Comments for planning application **2021/62/93013**. Erection of two storey side, single storey rear, and rear dormer extensions, and demolition of the existing garage at 74 Cleveland Road, Marsh HD1 4PW.

Client Usman
Project 1968 : 74 Cleveland Road : Domestic Extension
Title Proposed Elevations
Drawing Number

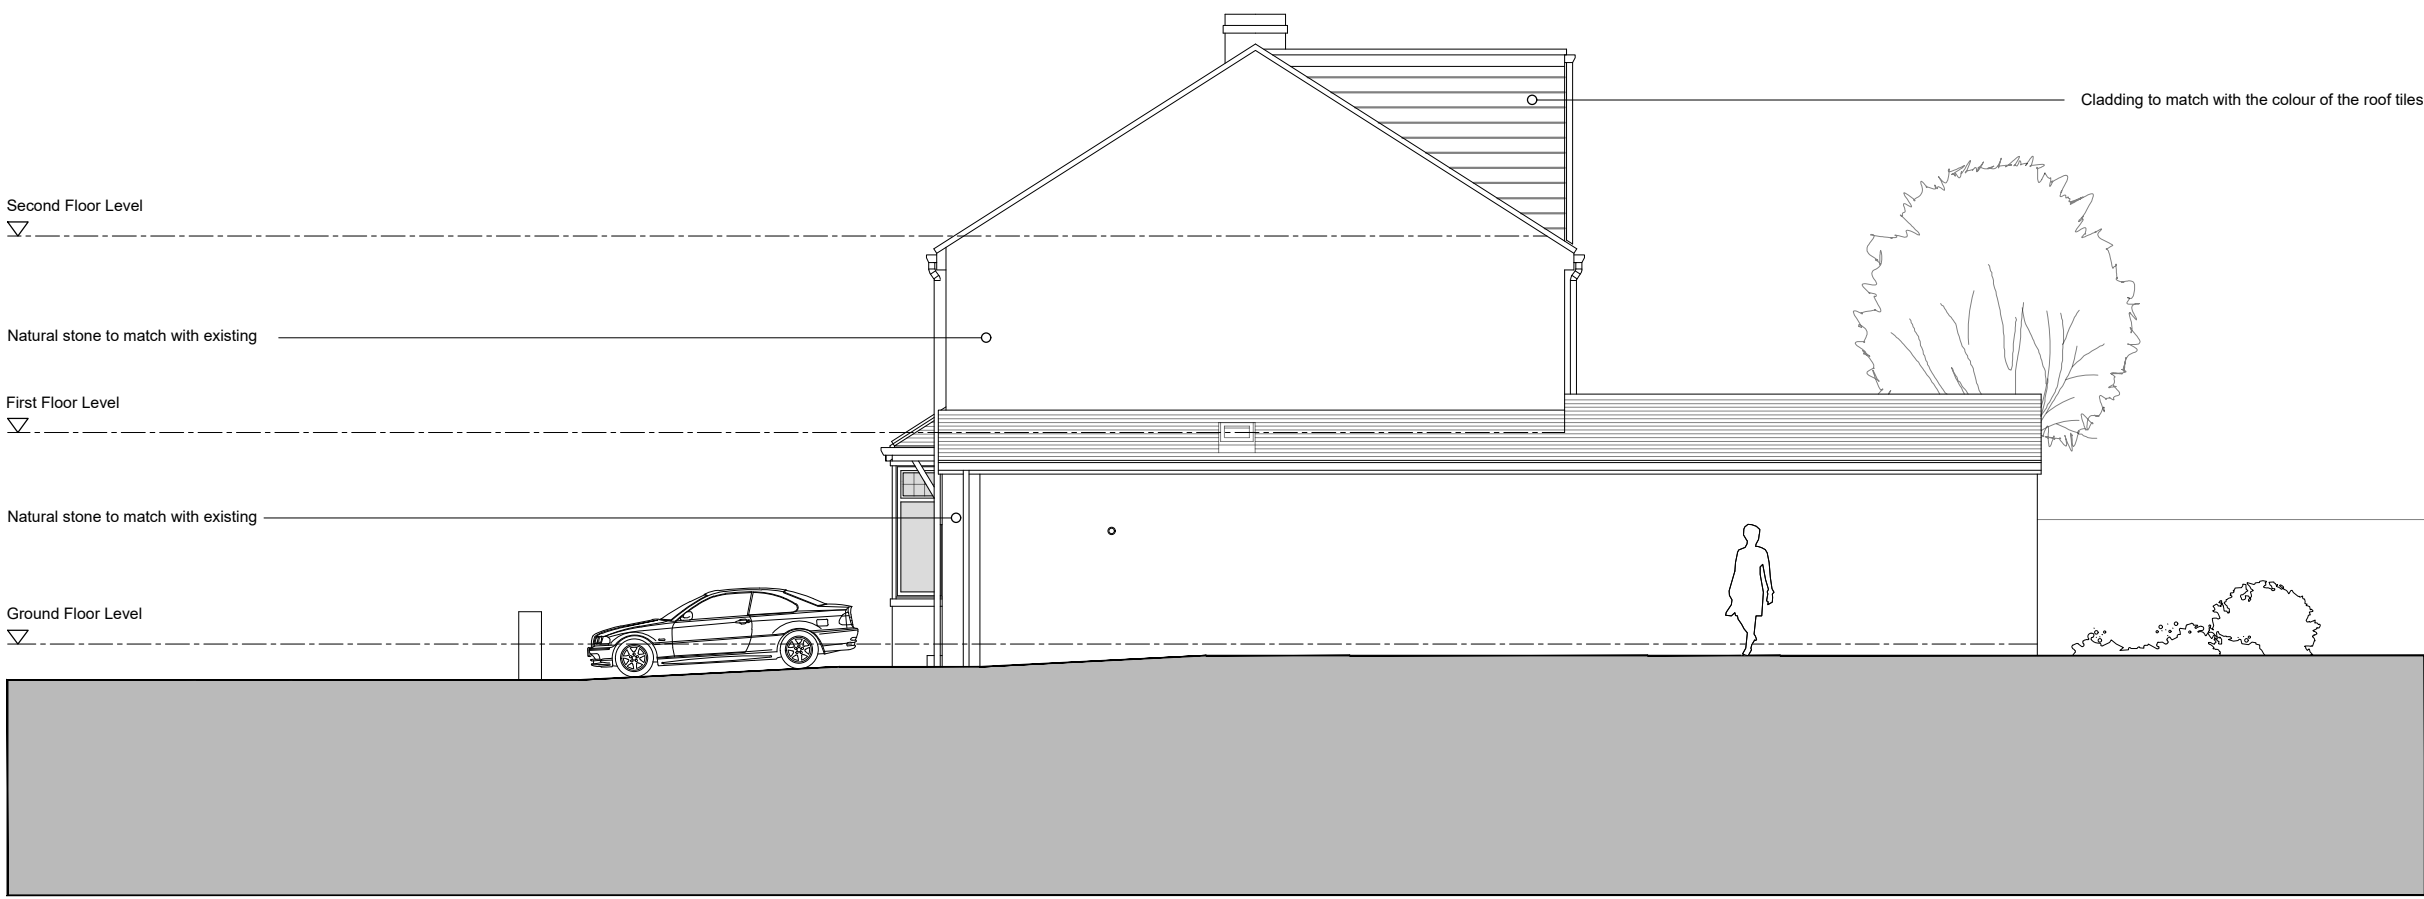
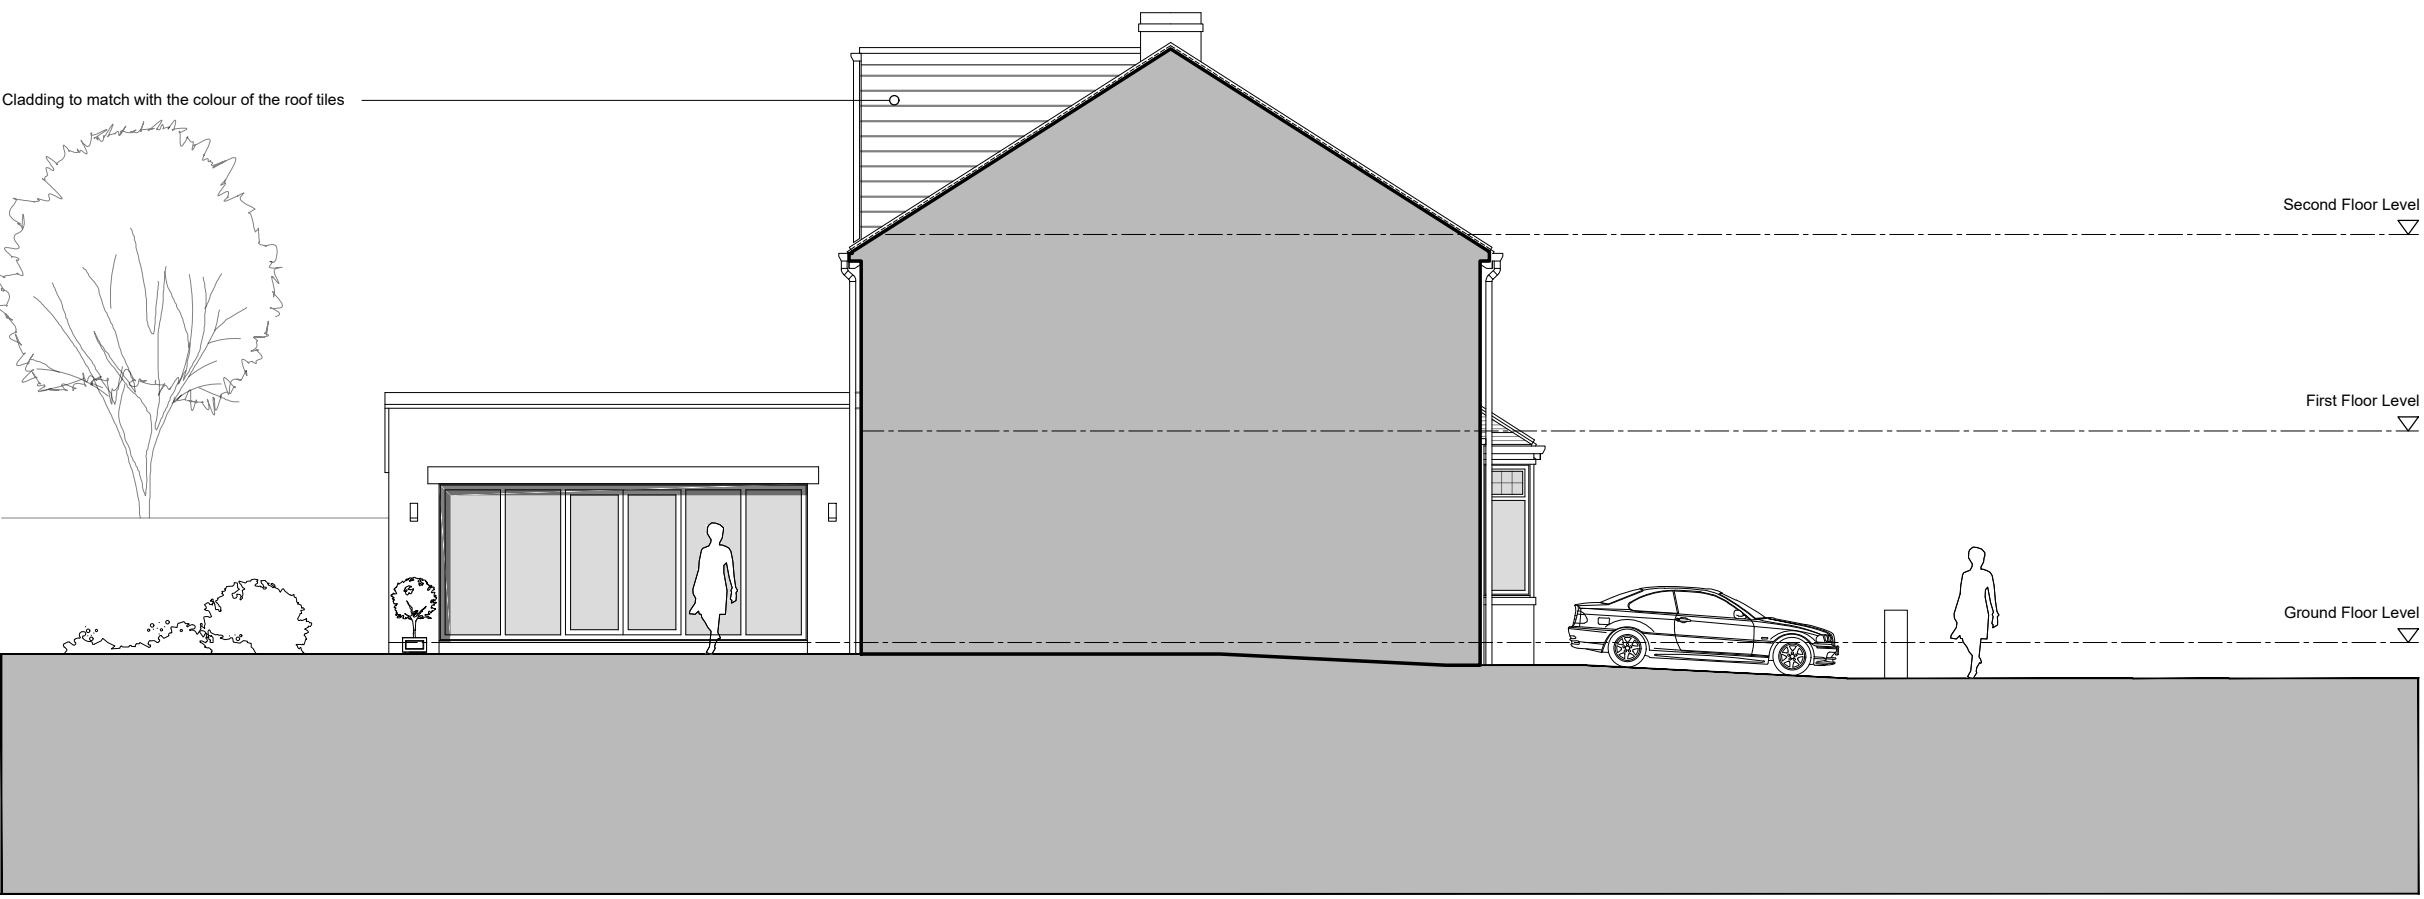
The proposed side extension coupled with the alterations of the roof will transform an existing hipped roof finish to a significantly extended pitched roof with a huge gable end resulting in a dominant overbearing addition to the property. The overall appearance of the existing semi-detached properties will be completely unbalanced, which would be an incongruous addition to its existing external appearance. The existing character of the area is dominated with buildings that have a hipped roof finish.

The proposed rear dormer will also add to the overall scale, bulk and mass of the proposed extension and introduce a dominant feature at a high level, which is very closely spaced to my rear facing windows. I appreciate that there are already facing windows at first floor level, but the dominant towering position of the proposed dormer extension results in facing windows at a significant height allowing a clear line of sight from a new second floor position, which will result in a significant loss of privacy.
